Proposed Elevations

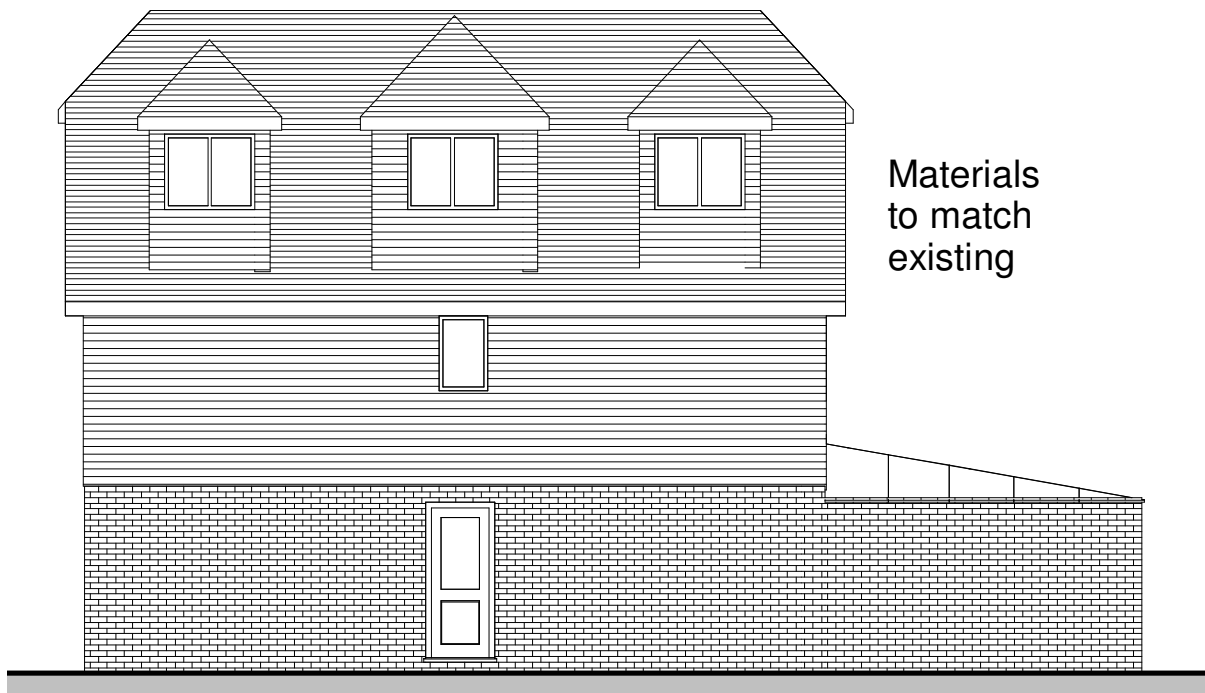
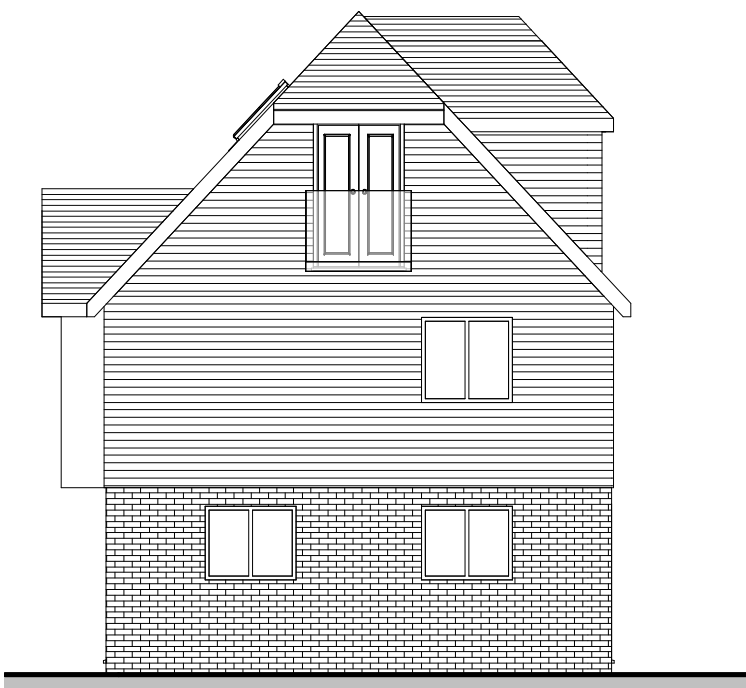
Are you able to confirm as to whether the elevations are labelled correctly? Apologies that this has come up reasonably late in the process.

Also, I am informing you that my Team Leader has concerns relating to potential for loss of privacy to adjacent occupiers, however, it could be considered that this can be mitigated via planning condition.

I've updated the Proposed Elevations and Loft Floor Plan to show the new window and that the rear bedroom window will be fixed close and obscure glazed. We don't want an extension of time for this window so it can go in as a minor amendment if necessary.

I apologise, I've updated the elevations to show the correct direction. I've also attached a section to show that the velux windows facing the side of the neighbouring property have a sill of 1.7m, Bedroom 5 only faces the side of the property to the South and the French doors face a field. The only other issue is Bedroom 6, that could have a view over the garden to the South, can we add a window in the gable end facing a car park?
